### INTAKE SCREENING COMMENTS RESPONSE

Permit Number **2208-260**

Project Address 8455 SE 83<sup>RD</sup> ST.  
Mercer Island, WA 98040

Subject **Response to Building Permit Intake Screening Comments**

**TS-1**

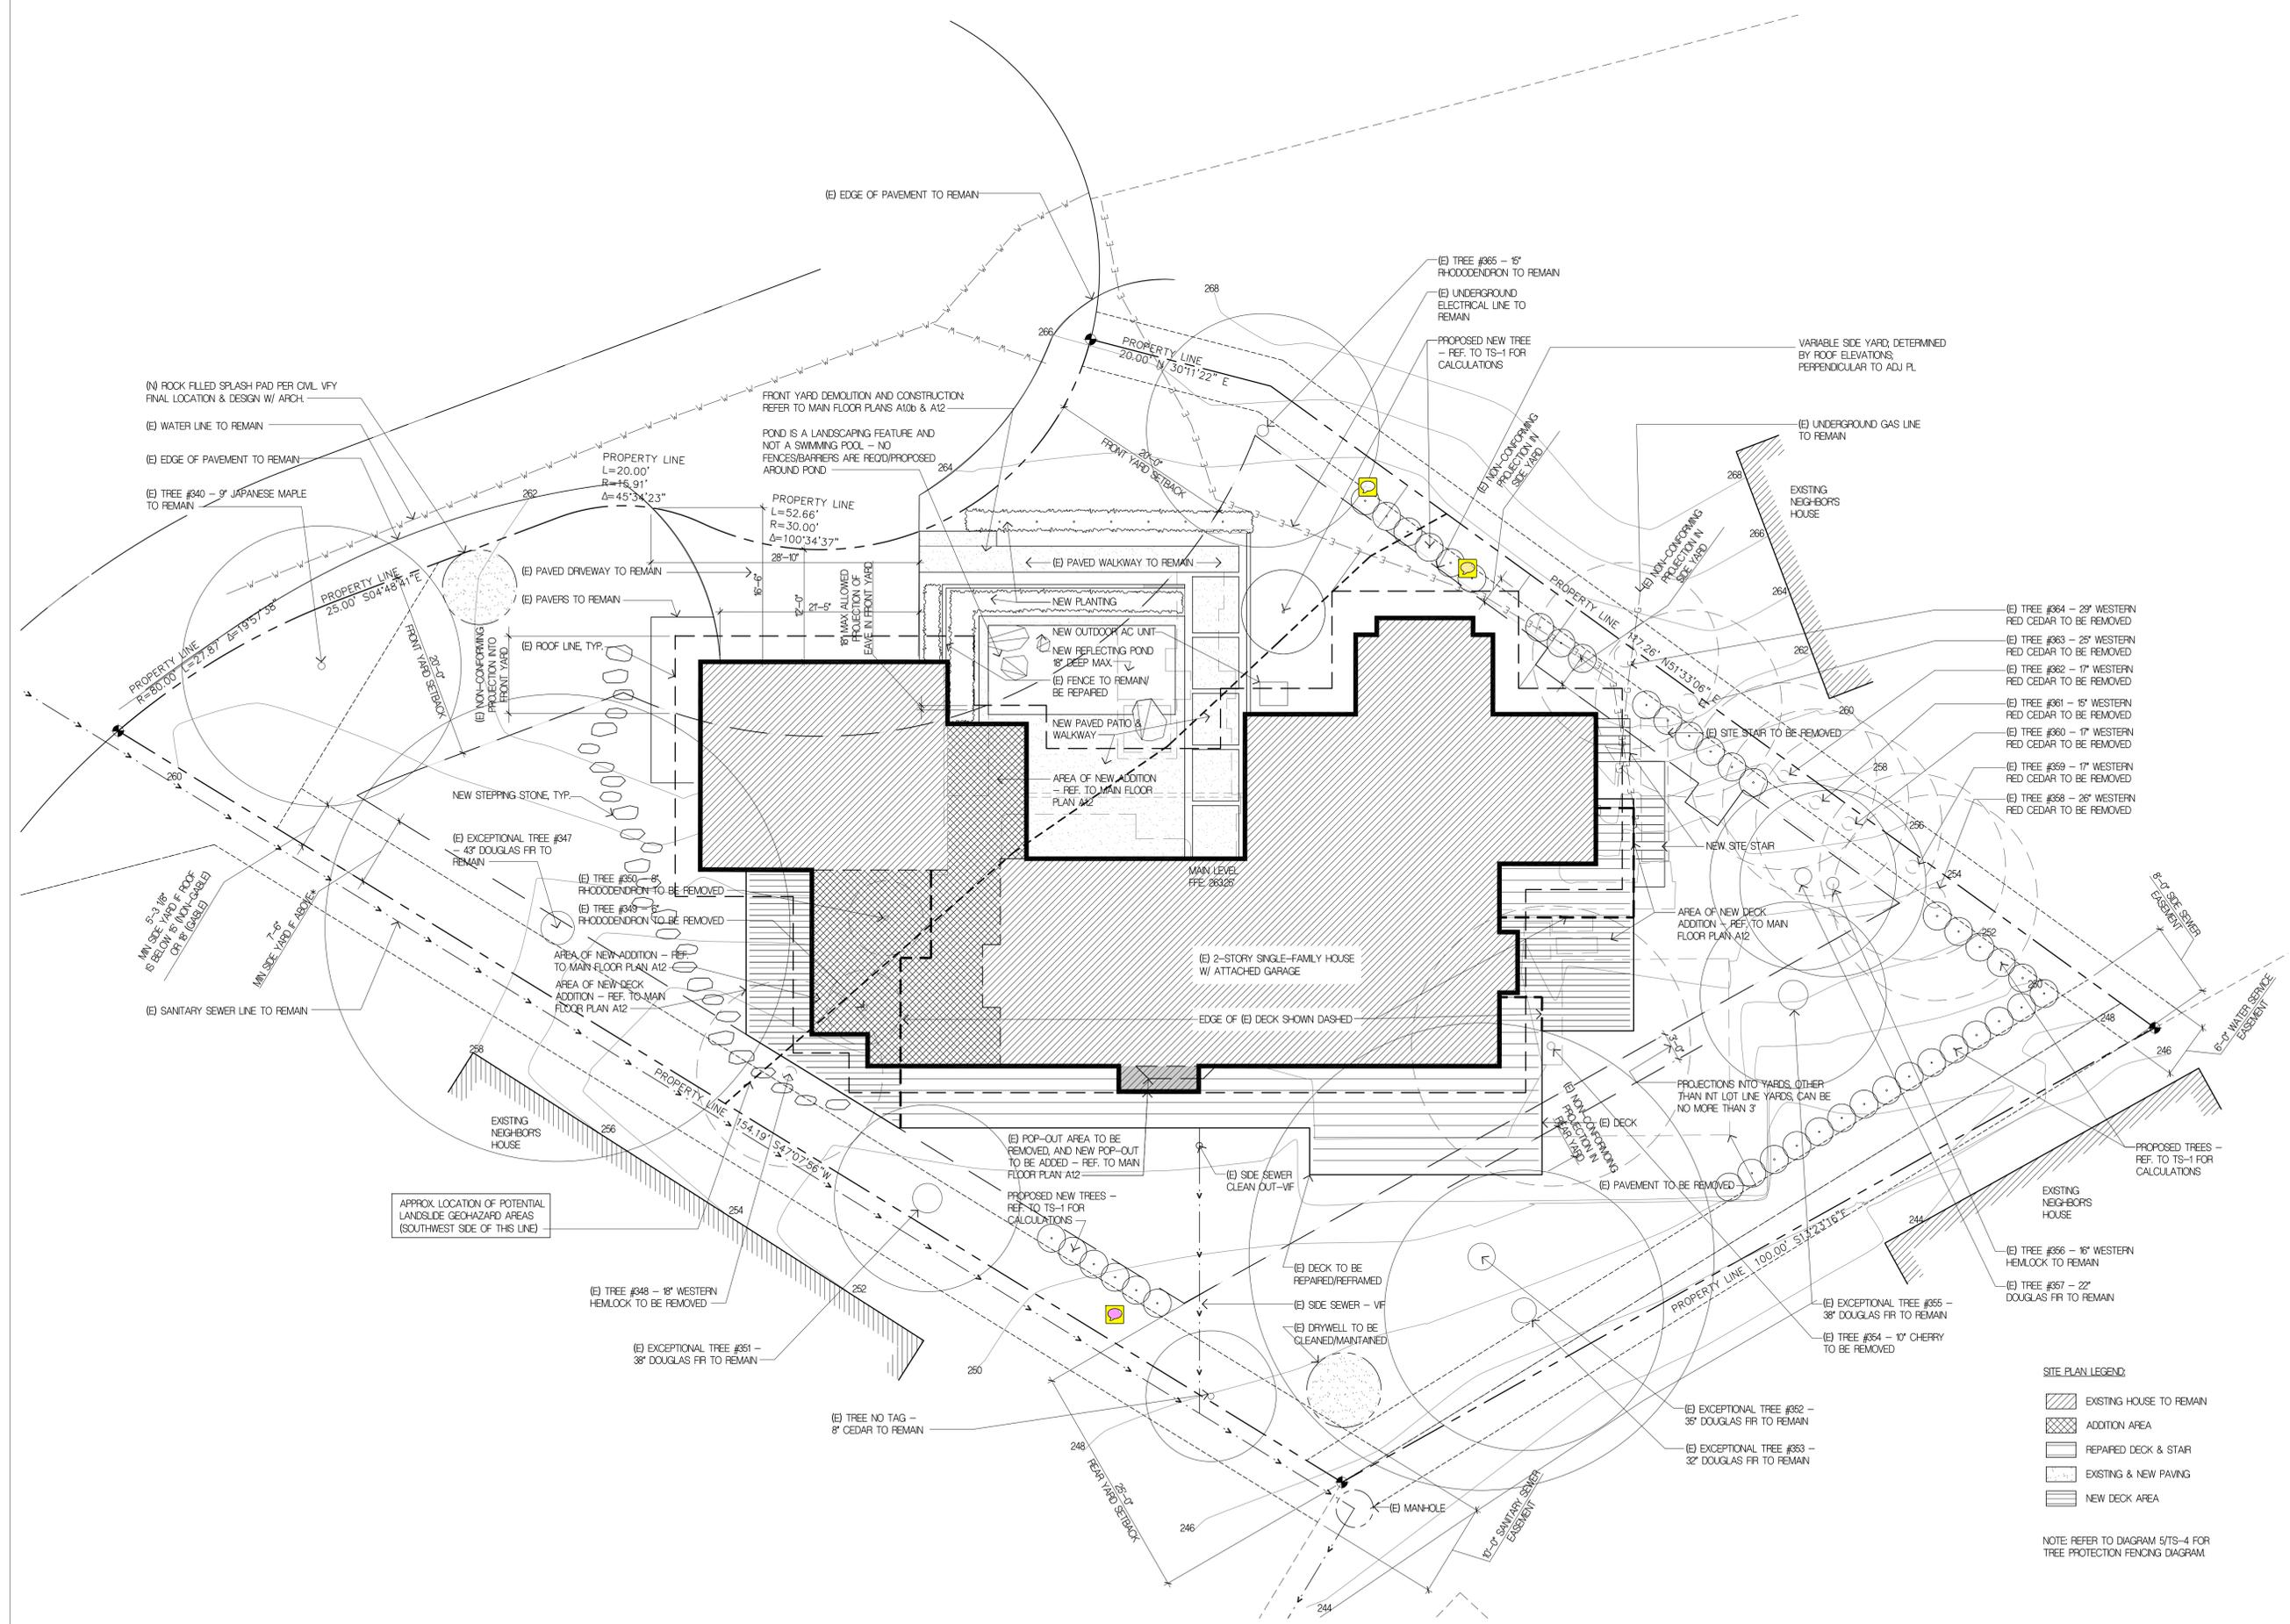
**2. Sign Posting and Notice of Application:**

**3. Seasonal Development Limitation Waiver:**

**4. Hold Harmless Agreement Document:**

**5. Water Supply System Requirements:**

#### Fire – Jeremy Hicks

Response: As directed in the comment, we added a note on TS-1 the Project Information Sheet under 'City Requirements' to post the sign.

Response: As directed in the comment, we added a note on TS-1 the Project Information Sheet under 'City Requirements' that a Waiver to the Seasonal Development Limitation is required if site work is proposed between 10/1 to 4/1.

Response: As directed in the comment, we added a note on TS-1 the Project Information Sheet under 'City Requirements' that the Owner is required to sign the agreement prior to the permit issuance.

Response: As directed in the comment, we added a note on TS-1 the Project Information Sheet under 'Water Service Notes' for the required Water Meter and Supply Line sizes.

1. **Fire Sprinkler System:**  
Response: Required system NFPA 13R is noted on TS-1 the Project Information sheet, under 'Fire Protection Notes'
2. **Monitored Household Fire Alarm:**  
Response: As directed in the comment, required NFPA 72 Fire Alarm is noted on TS-1 the Project Information sheet, under 'Fire Protection Notes'
